Re: Draft Comments Report
265 Carling Avenue, Ottawa, Ontario
GW File No.: 23-293 – Response Letter

Gradient Wind Engineering Inc. (Gradient Wind) was retained by Katasa Groupe + Developpement to undertake a detailed traffic noise assessment for the proposed development located at 265 Carling Avenue in Ottawa, Ontario. This addendum letter is supplemental to our previous report (ref. *Gradient Wind report #23-293 – Detailed Traffic Noise Study*, dated January 23, 2024), to address the comments received by the City of Ottawa on July 19, 2024.

2 ROOF & MPH PLAN - STAGE 1

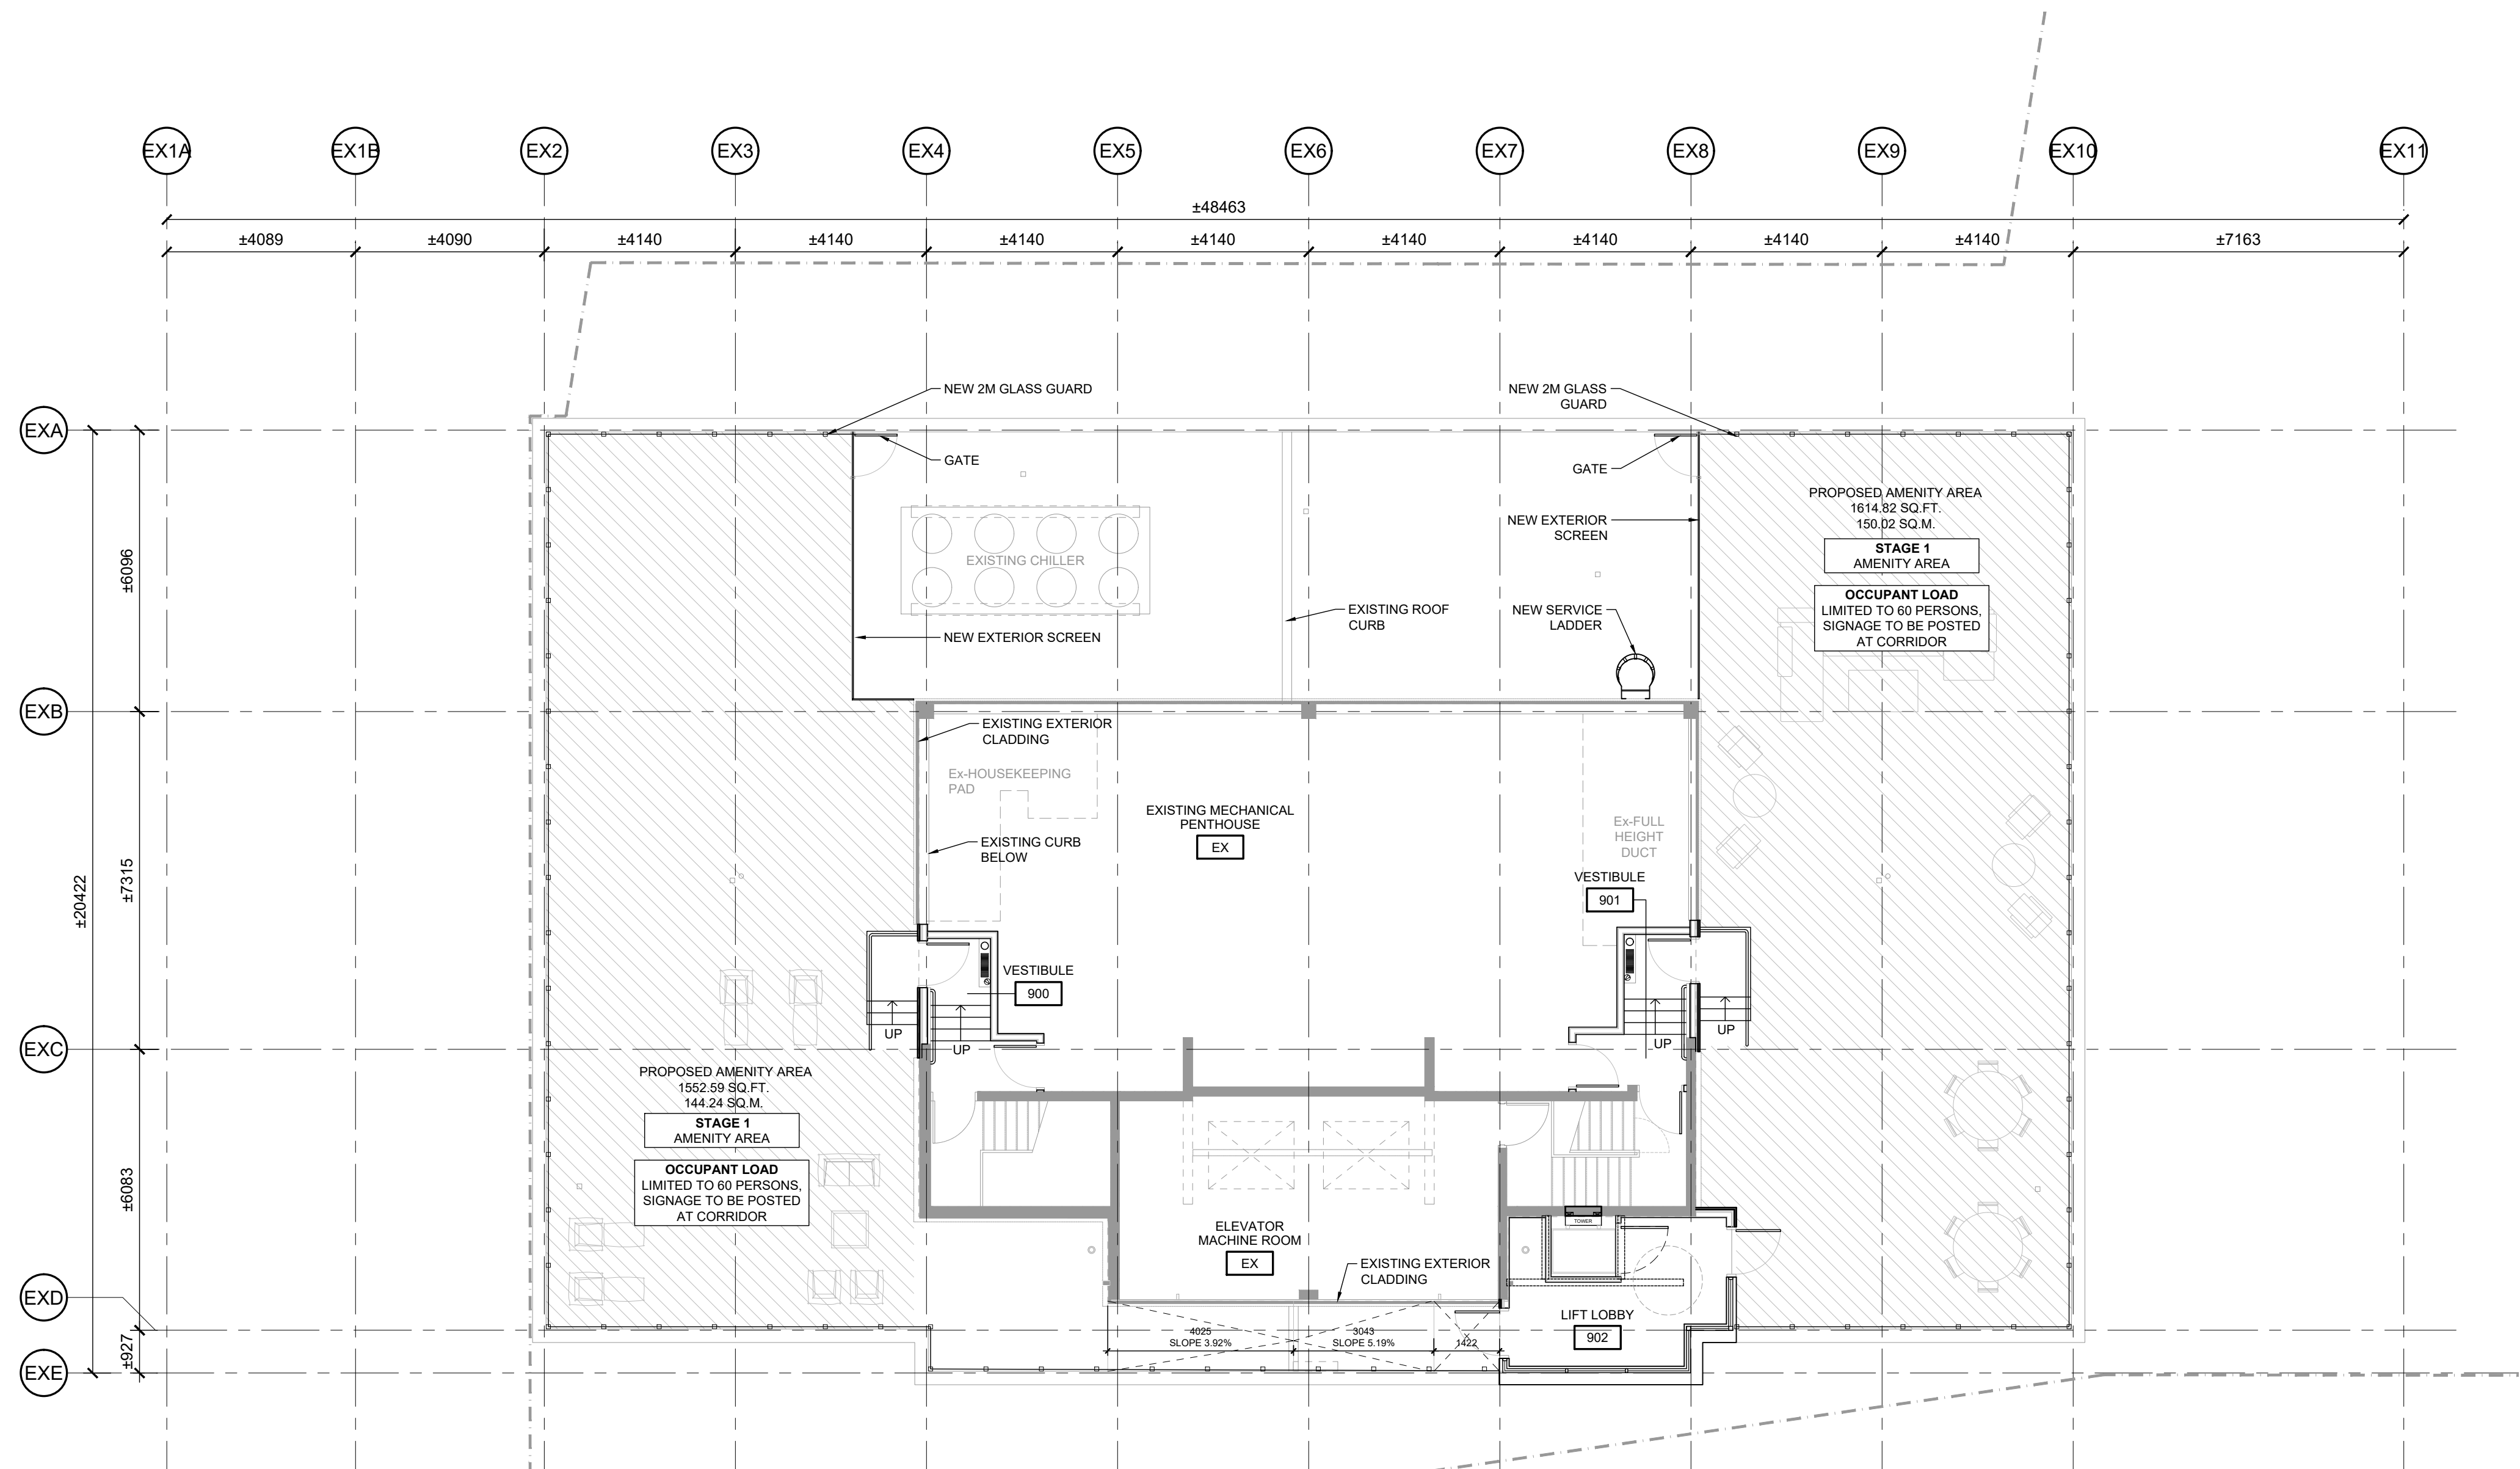
Comment 3.b: *“We understand that a roof top amenity is proposed. Please confirm this and any other proposed exterior amenity space, and provide applicable recommendations, as required”*

GW Response: There are two amenity spaces located on the roof of the building. One on the east and west sides of the mechanical penthouse. Gradient Wind performed noise calculations at the centre of each area as per ENCG requirement. The primary sources of noise are Carling Avenue, Bronson Avenue, and Highway 417. Table 1 (below) summarizes the AADT values used for each roadway included in this assessment. Figure 1 shows the receptor locations and source – receiver distances. Details of the STAMSON calculations are shown in Appendix A.

Since the levels of both OLA receivers are greater than 60 dBA, therefore noise barriers will be need around the perimeter of terraces. Our recommendation is to use a 2.0 -meter-high barrier, in order to reduces noise level to 59 dBA. Noise barrier locations are shown in Figure 2.
